Muswellbrook Battery
Energy Storage System

11 October 2022

Muswellbrook Battery Energy Storage System (BESS) (SSD-29704663)
Muswellbrook Shire Council Comments on Environmental Impact Statement (EIS)

Figure 5-1: Transformer Bund Fire Radiant Heat Contours

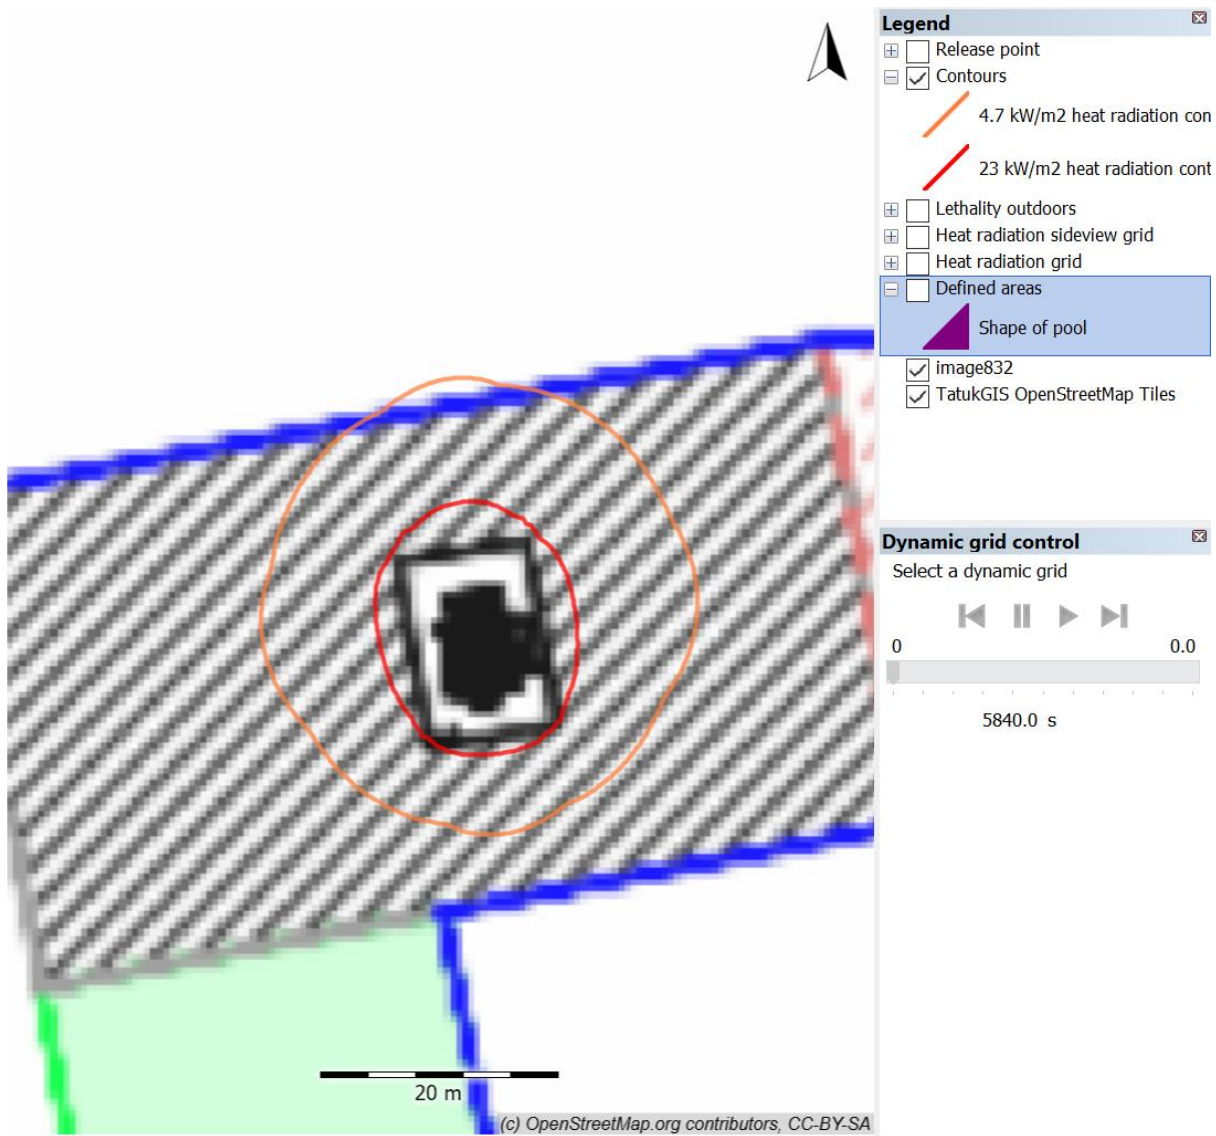
22. Clarification is required on the accepted heat radiation criterion (including wind conditions). Section 4.1 of the PHA references both a 4.7 kW/m² for fire impacts and 23 kW/m² for property damage and accident propagation. Table B-1 describes the associated physical impacts for each, as follows:

- a) The reference to 23 kW/m² is referenced in Section 6.6.3.1 of the EIS to justify impacts from li-ion battery fault, thermal runaway and fire (*which has not been used as a justification in the PHA for this impact*); and
- b) Section 6.7.4 of the EIS states “Implementation of a 10 metre wide Asset Protection Zone (APZ) around the BESS and associated buildings, to ensure that radiant heat levels at the building surface remain below 29kW/m²” (*a level of 29kW/m² seems dangerous when compared to Table B-1*).

**Figure 5** below shows an indicative strategy to manage surface water at the site as discussed above. Please note that this strategy is conceptual only to provide context and will need revising at detail design stage. Please refer to **Appendix A** for typical detail of level spreaders.

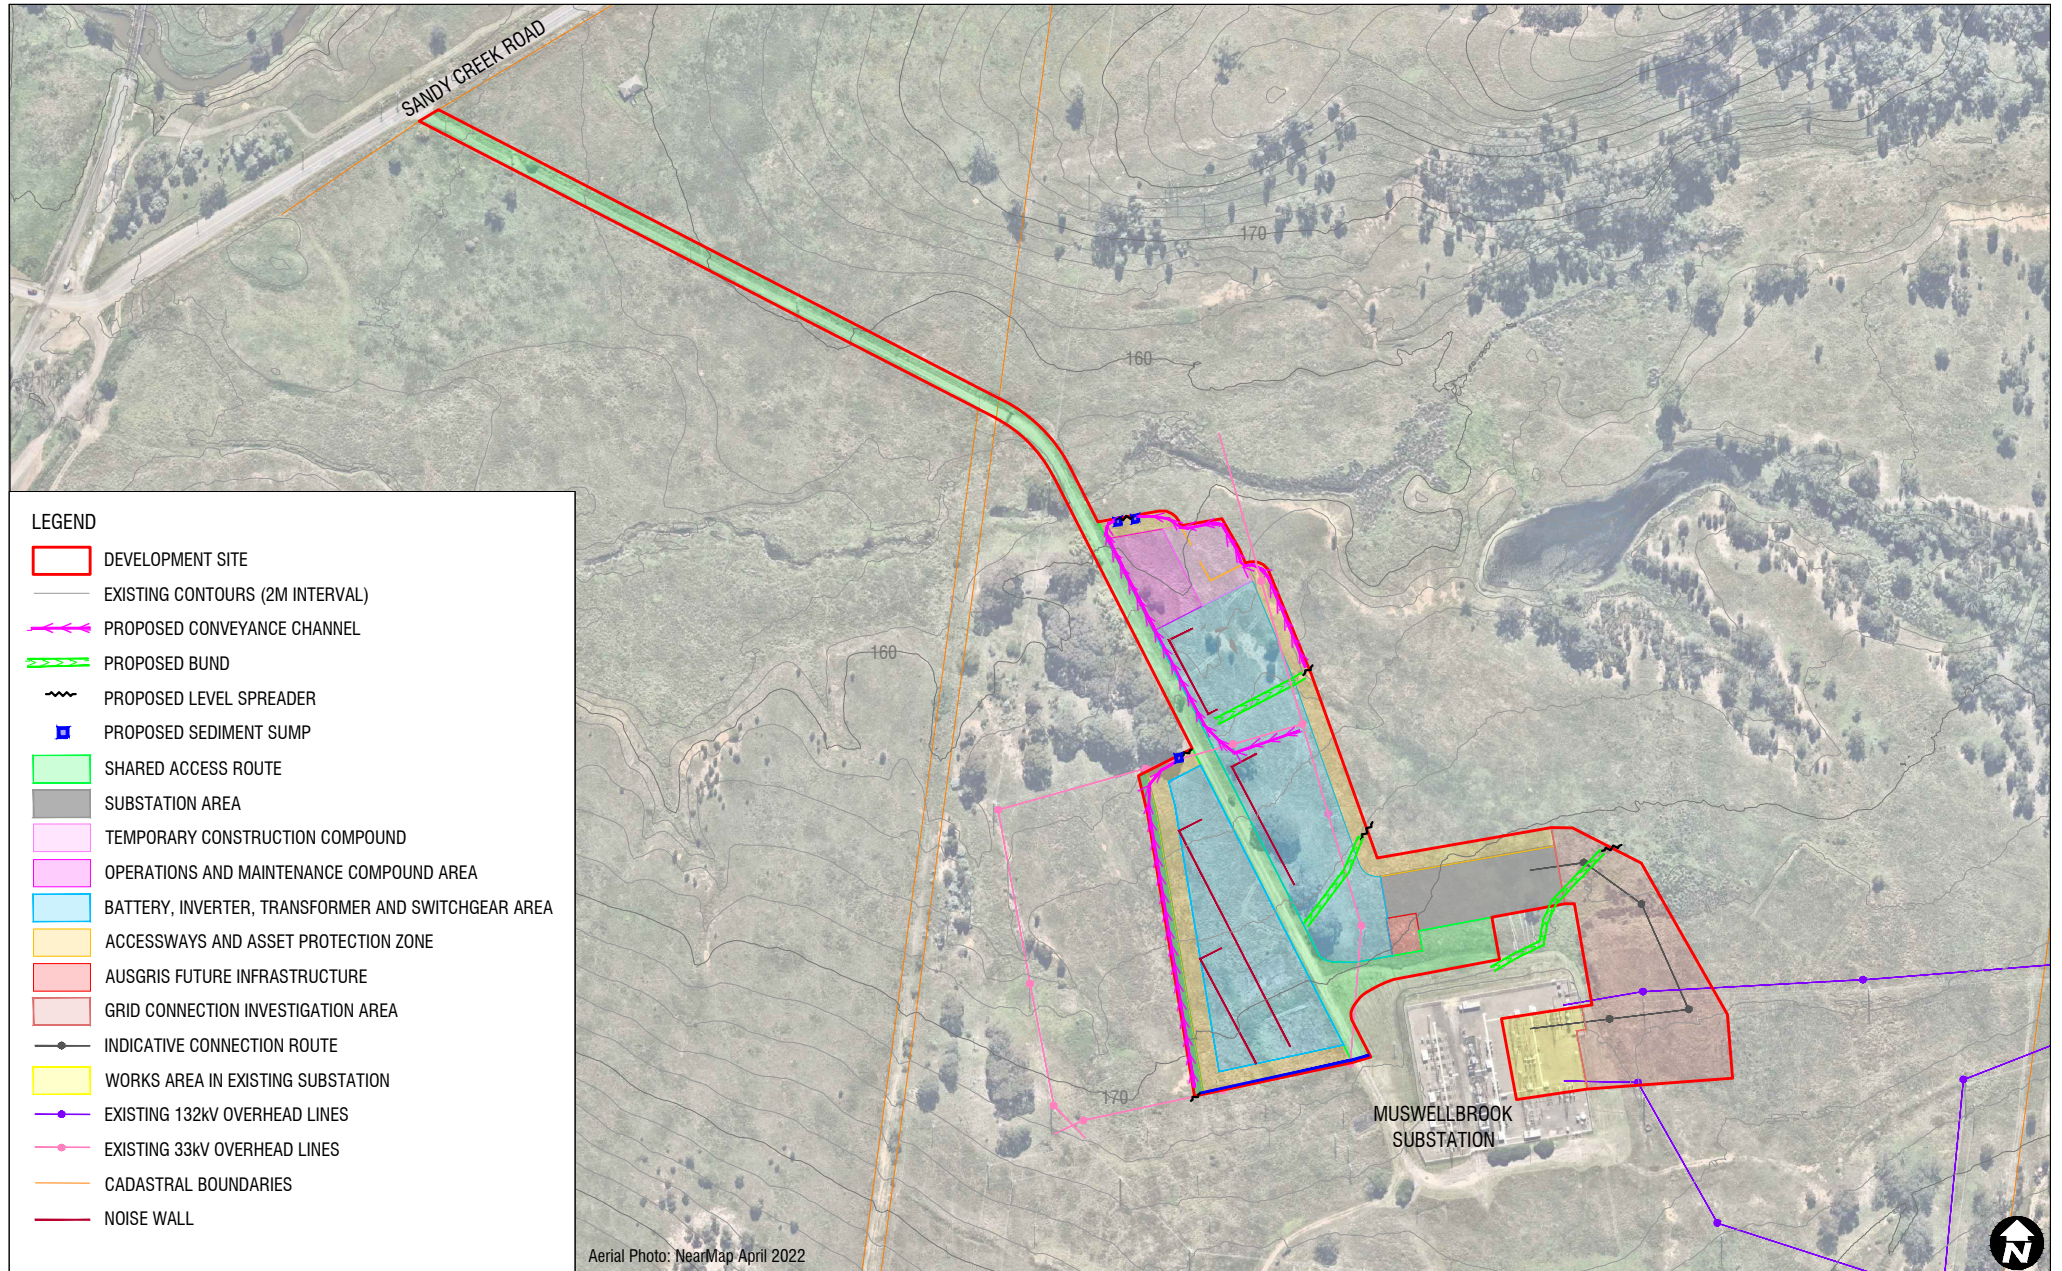
29. Emergency isolation measures for the drainage systems are to be detailed including in case of a fire, as well as drainage of the hardstand areas, with all drainage infrastructure be designed for construction, operational and decommissioning traffic loading. Overflow routes and erosion management controls for stormwater should also be included, and form part of a DRAINS model.

FIGURE 2-3 INDICATIVE CHARACTER OF PROPOSED SCREENING VEGETATION

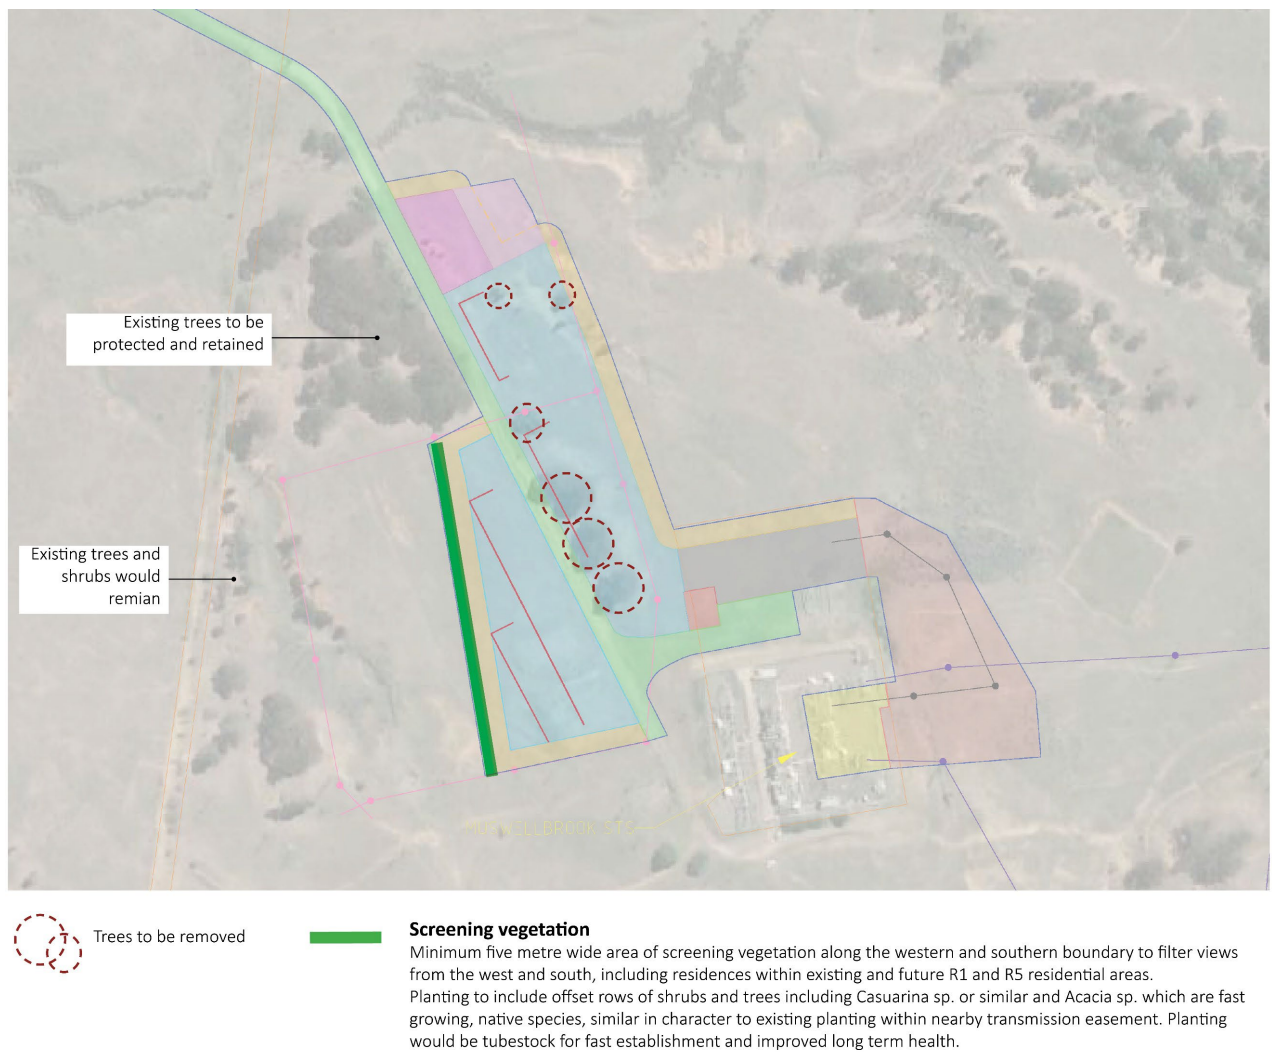
18. The indicative character of proposed screening vegetation as shown in Figure 2-3 of the Visual Impact Assessment is supported.
19. Council Officers support the following operational mitigation measures as outlined in the Visual Impact Assessment:
